Your Ref: 100651034-002
Our Ref: 23/03234/LBC

Date 8th December 2023

Application No: 23/03234/LBC
Proposal: Listed building consent for replacement windows and internal alterations
Address: Guardbridge Hotel 1 Old St Andrews Road Guardbridge St Andrews Fife

proposed - replacement window details

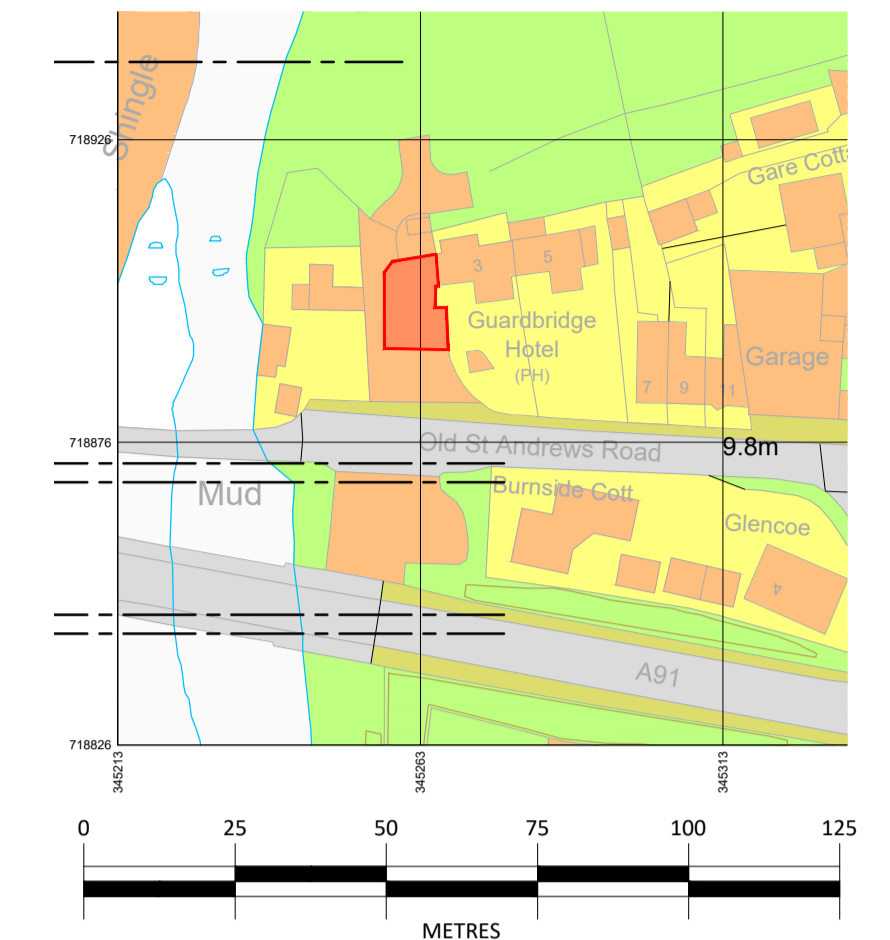
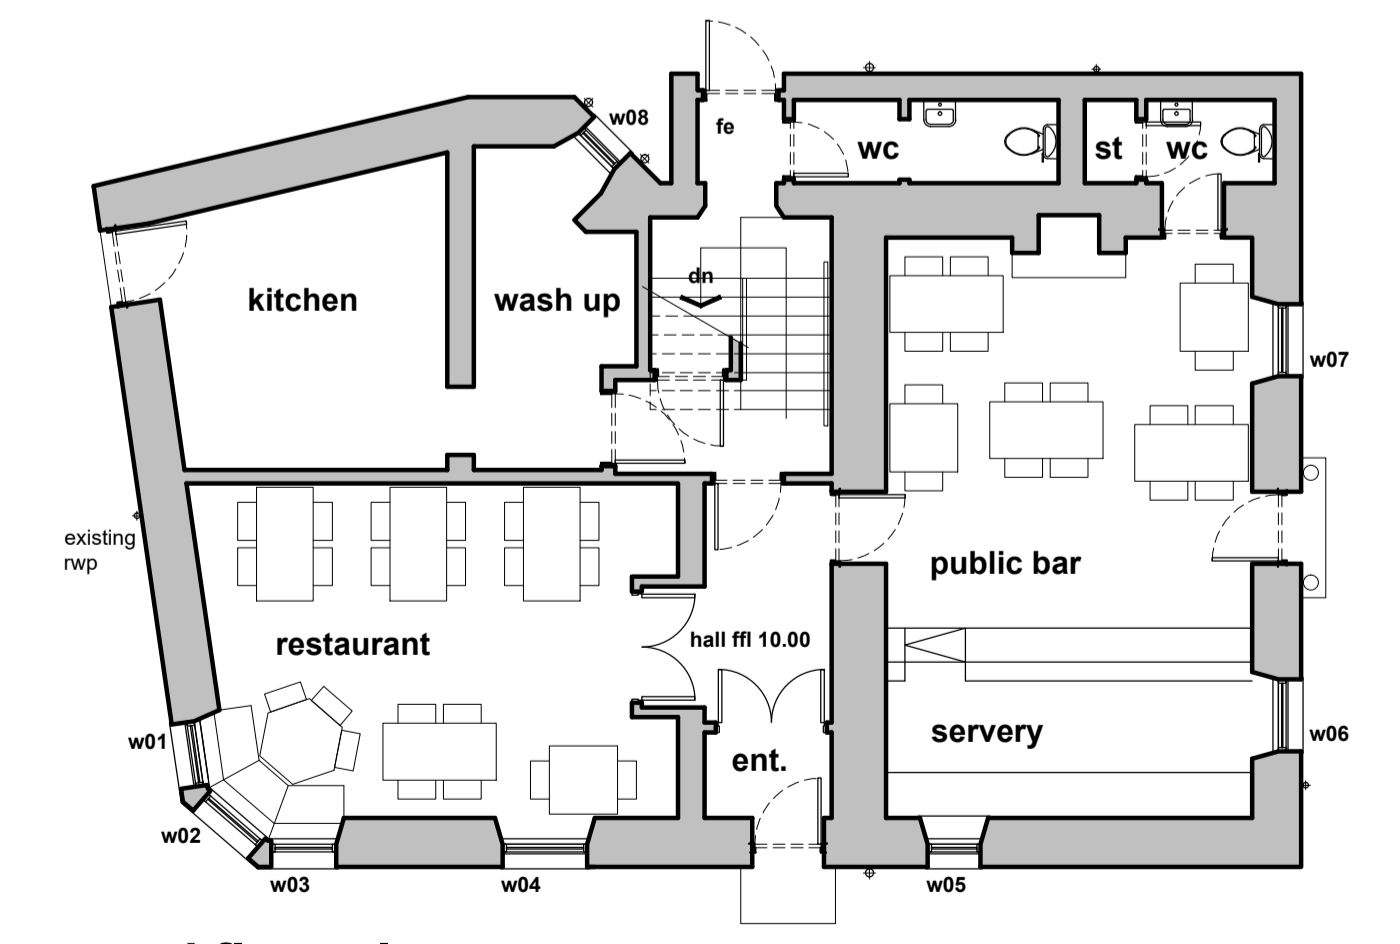
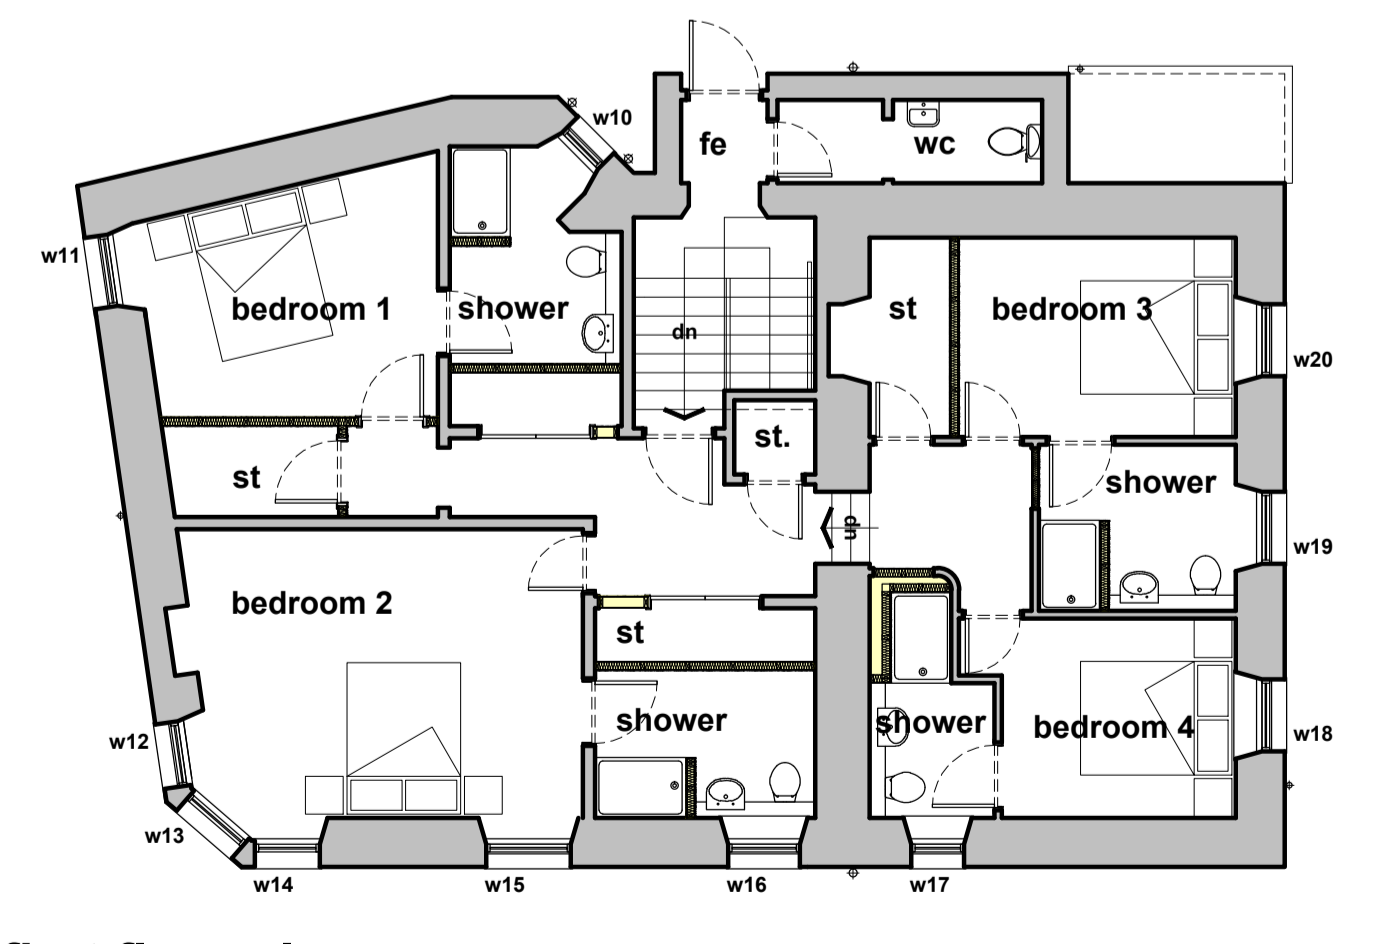
1. Further details of the windows is required. Please submit existing and proposed window details, including elevation drawings to a scale of 1:20. If multiple windows are the same dimensions and design one drawing of the type will suffice. Please label drawings to reflect the window designations on the existing plans. Please also include existing and proposed sections and astragal details at a scale of 1:1. Photos of existing windows as well as brochure extract of the proposed windows would also be helpful for assessing the proposal, if available.
